**KIRKLEES METROPOLITAN COUNCIL**

**UPDATE OF LIST OF PLANNING APPLICATIONS TO BE DECIDED BY  
STRATEGIC PLANNING COMMITTEE**

**Planning Application 2024/93494**

**Victoria Tower, Castle Hill, Lumb Lane, Almondbury, Huddersfield, HD4 6TA**

General Arrangement and Site Clearance

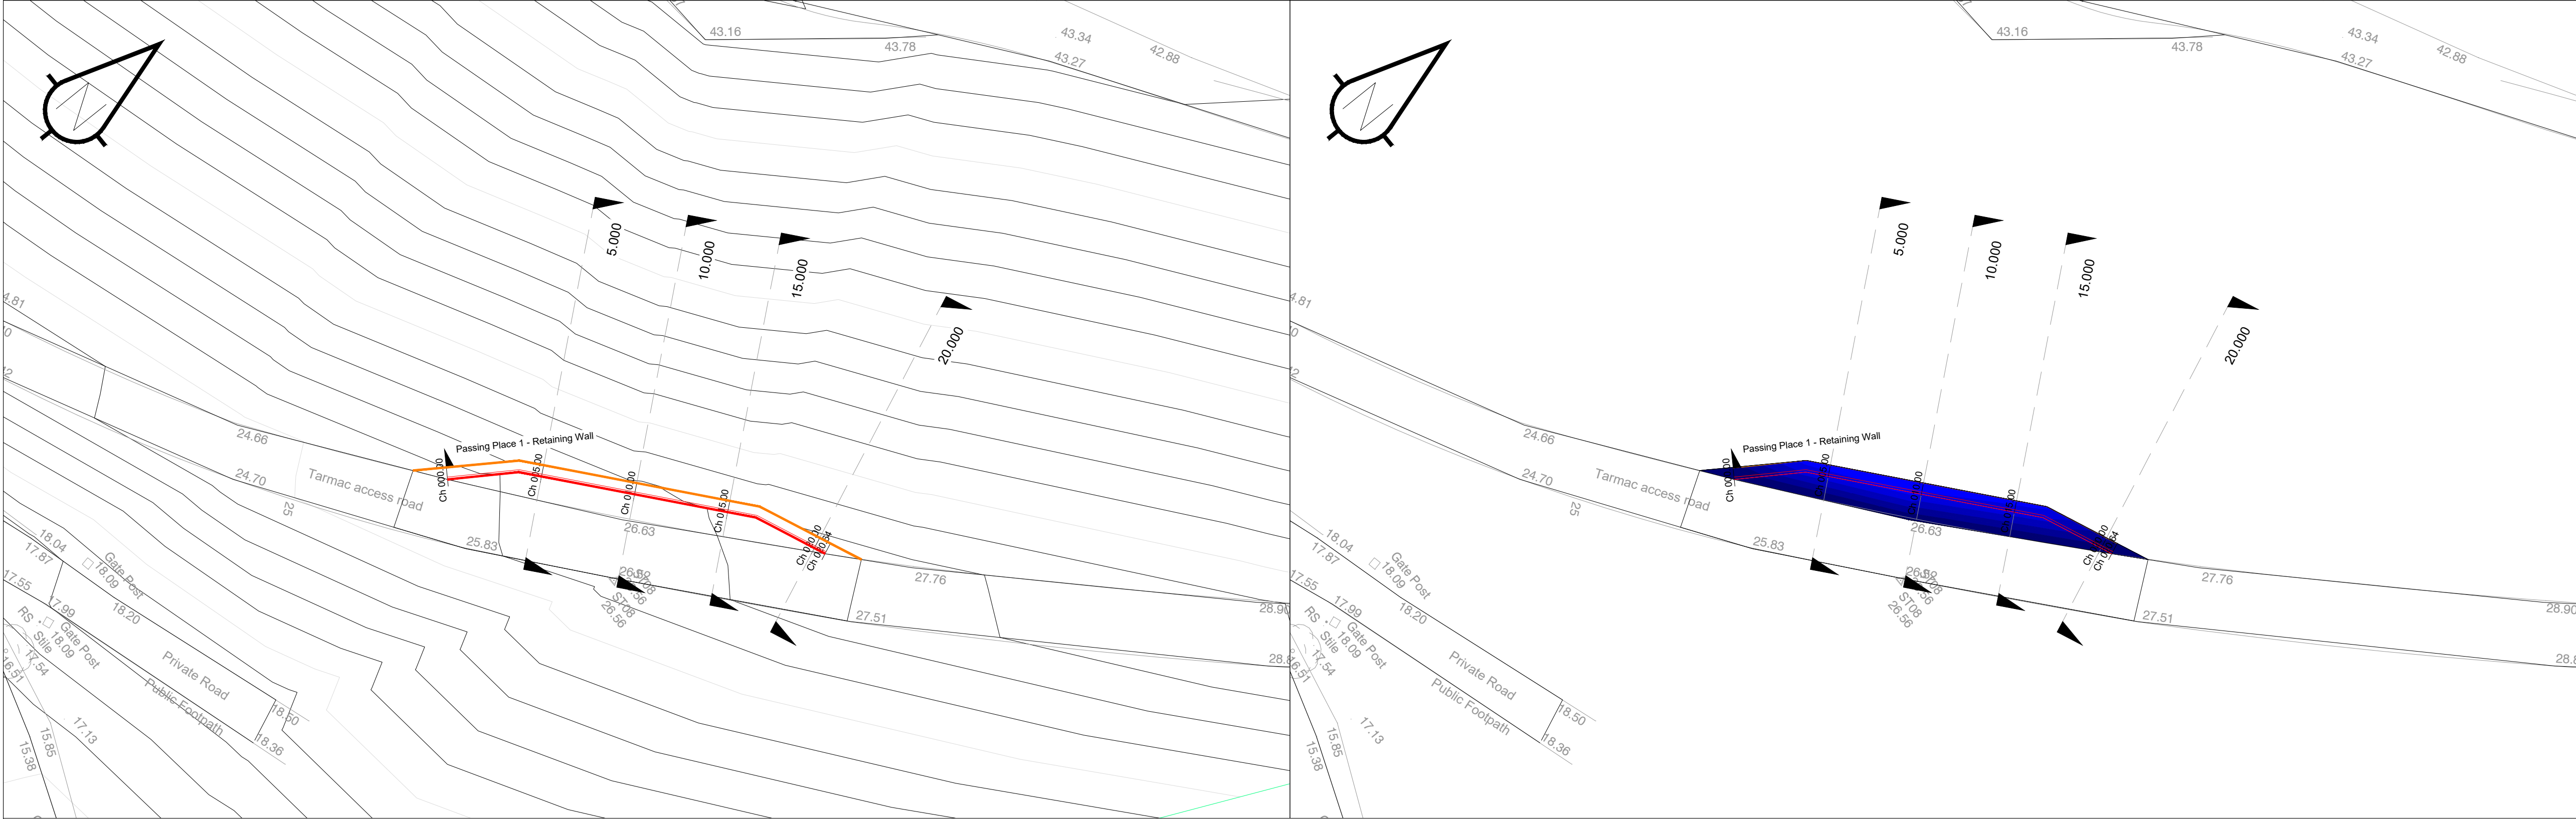
K.C. Highways have advised that condition 9, as drafted in the committee report, be amended to the version provided below along with an additional informative note. The condition amendment reflects current practises, simply requiring that the development be undertaken in accordance with the approved details, as opposed to requiring the submission of a further scheme. The details, as submitted, are considered adequate for planning purposes and therefore further details are not necessary.

*9. Prior to the development being brought into use, the Highway access works as shown indicatively on the General Arrangement and Site Clearance plan Drawing No.156199-100-001 Rev. A, comprising of passing places and associated lining and signing at Castle Hill Side shall be fully constructed and made operational.*
